Application by Morecambe Offshore Wind Limited for Morecambe Offshore Windfarm Generation Assets

The Examining Authority's additional written questions and requests for information (ExQ3)

Issued on 25 March 2025

LEGEND

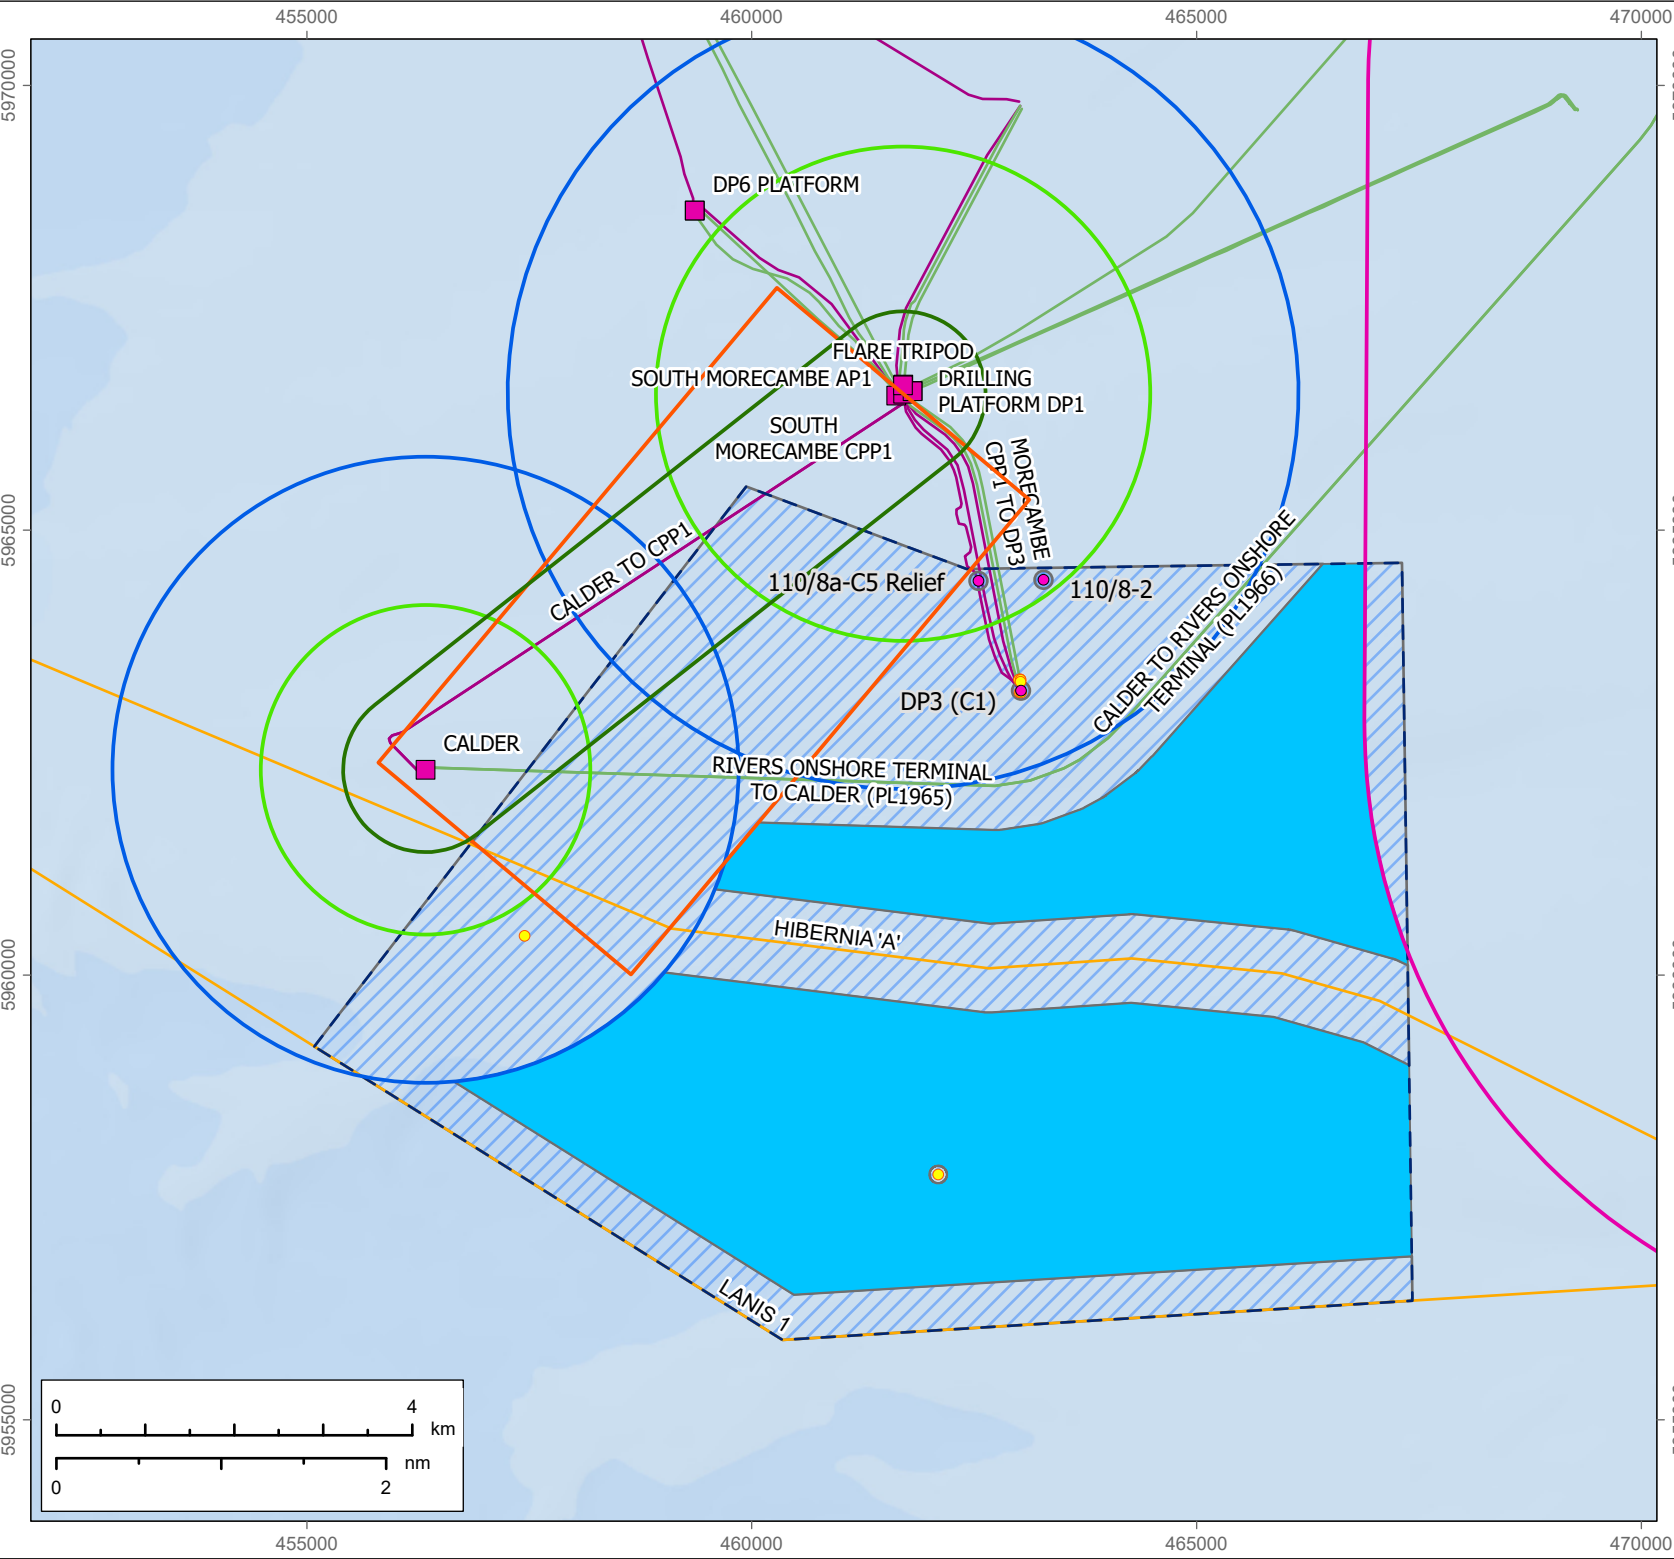
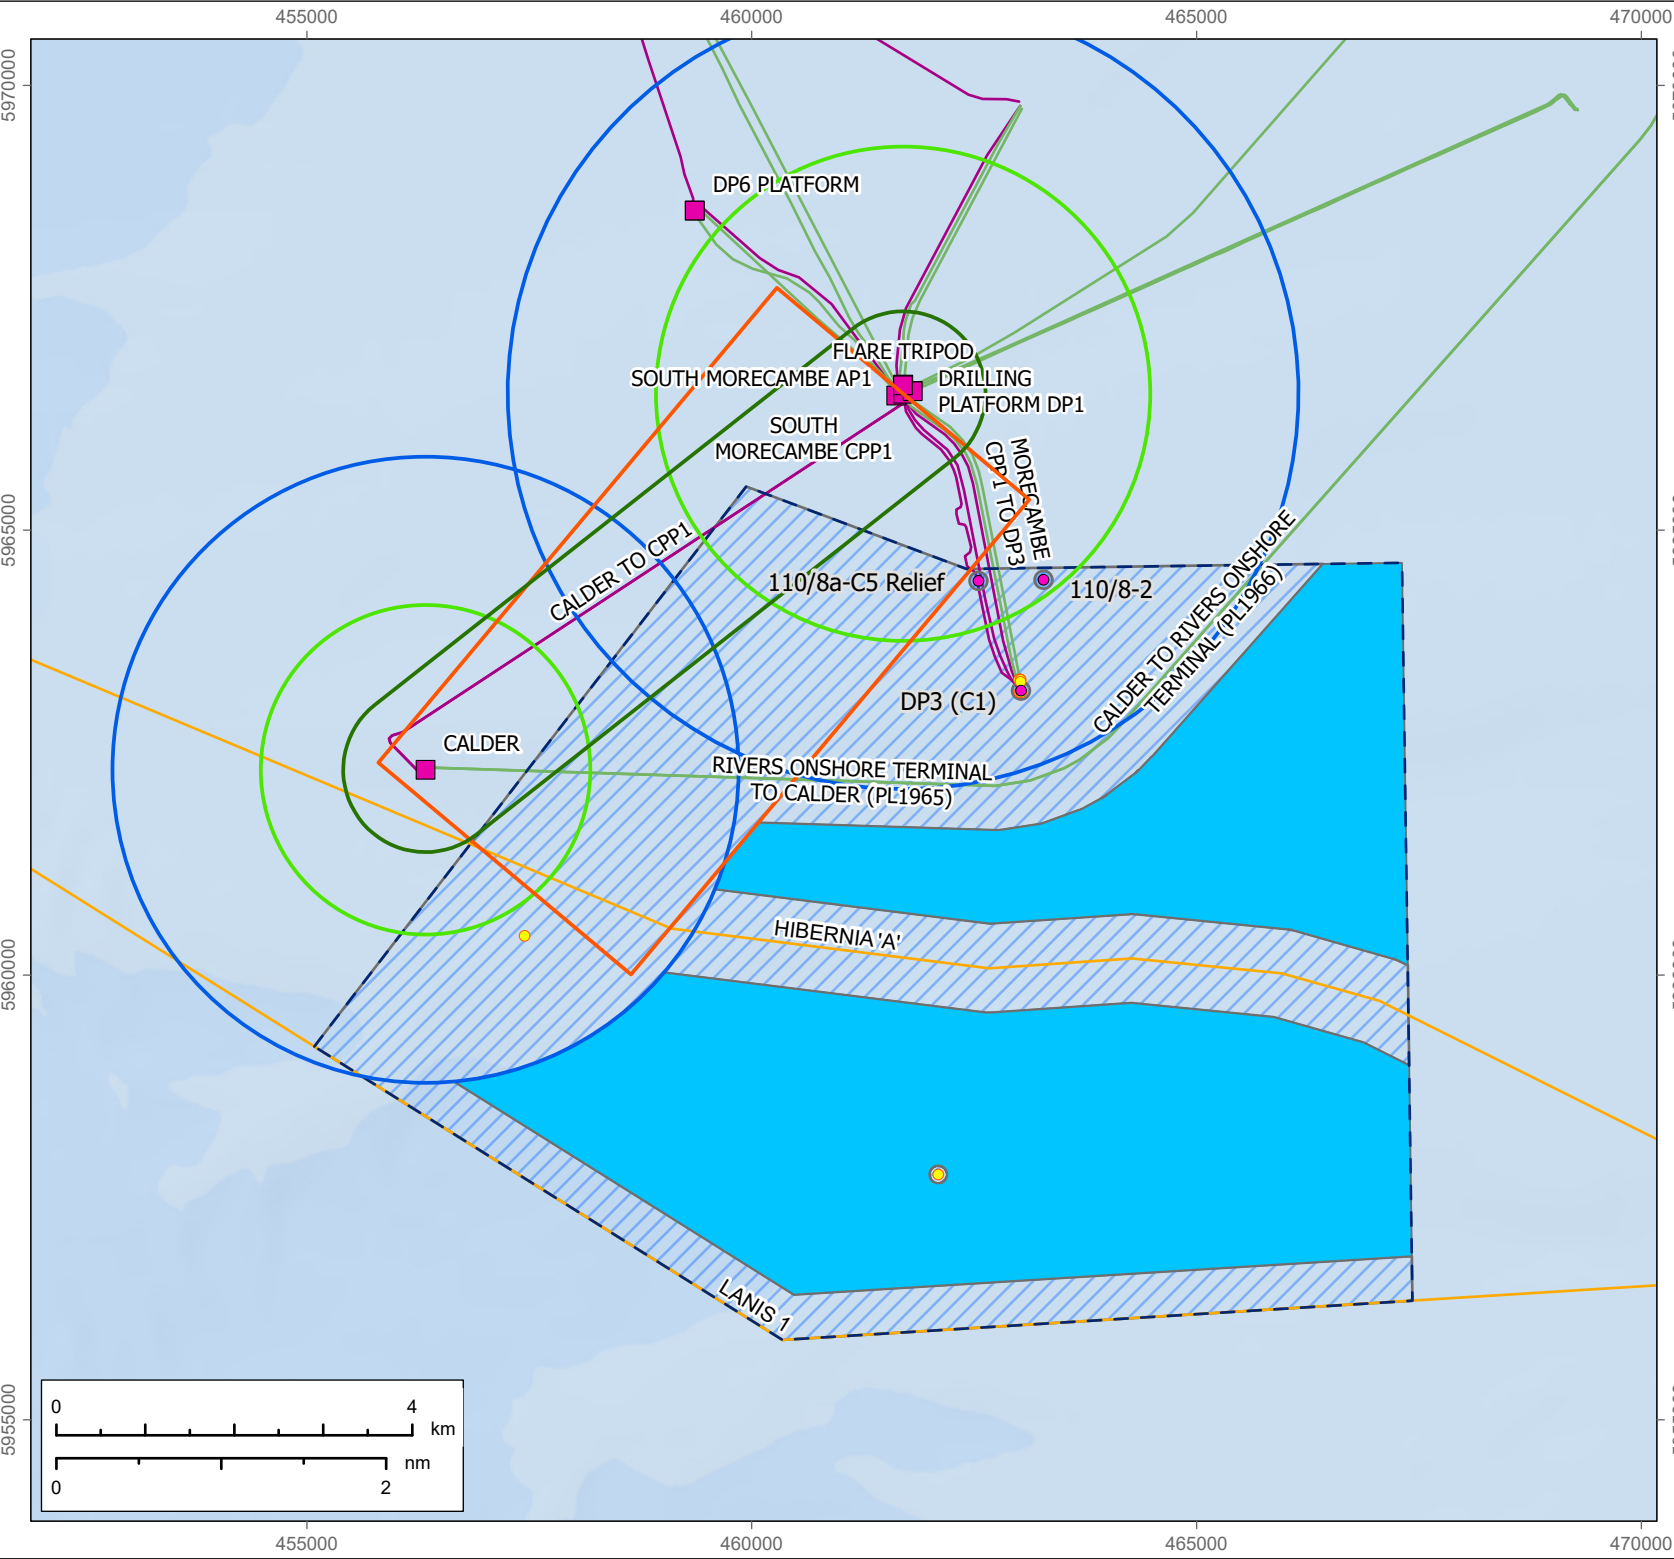
ExQ3	Question to:	Question:										
3GEN3.	The applicant	<p>Liverpool Bay SPA and Oil and Gas Platform Buffers</p> <p>Whilst the ExA notes the caveats stated in the applicant’s response to ExQ2HRA6 at D5 [REP5-070], to further demonstrate and support the applicant’s position:</p> <p>a) please can the applicant provide individual plans to demonstrate the impact that each of the incrementally smaller buffers from the original Liverpool Bay SPA would have on the layout and number of WTGs that could be accommodated within the site (i.e. 10km, 9km, 8km, 7km and so no buffer associated with the SPA affects the site) - with all other existing buffers/ corridors as shown on [REP5-007] unchanged.</p> <p>b) in Spirit Energy’s response to ExQ2CAR5 at D5 [REP5-090] it advises a buffer distance of 1.9nm is the minimum acceptable requirement for safe landing and take-off in daytime VMC and for night VMC this distance would be 2.4nm. In light of this could the applicant provide plans for each alternative SPA buffer scenario in (a) plus each of the increased buffer scenarios from the Calder and CCP1 platforms as set out in the following table.</p>

<table><tr><th><u>CPP1 WTG and OSP Aviation Buffer</u></th><th><u>Calder WTG and OSP Buffer</u></th></tr><tr><td>2.4nm</td><td>1.9nm</td></tr></table>

<p>c) any additional comments or further information the applicant wishes to provide on the implications of each of the above scenarios (noting the applicant’s previous response [REP5-070], EXQ2HRA3 and 2HRA6].</p> <p>The ExA is seeking a complete set of alternative scenarios shown on plans, so that, whatever the SoS may determine, if they felt it was appropriate they could include the relevant plan within any final DCO without having to revert to the applicant for that plan. Each should therefore have a different drawing number.</p>	<u>CPP1 WTG and OSP Aviation Buffer</u>	<u>Calder WTG and OSP Buffer</u>	1.9nm	1.9nm	2.4nm	1.9nm	1.9nm	2.4nm	2.4nm	2.4nm
<u>CPP1 WTG and OSP Aviation Buffer</u>	<u>Calder WTG and OSP Buffer</u>											
1.9nm	1.9nm											
2.4nm	1.9nm											
1.9nm	2.4nm											
2.4nm	2.4nm											
3GEN4.	The applicant	<p>Design Statement - Cabling</p> <p>Could the applicant please explain why (former) provision DC15 relating to use of the most direct/ efficient cabling route to minimise cutting has been deleted from the post-consent design code in Table 6.1 of the Design Statement [REP5-008] and [REP5-009].</p>
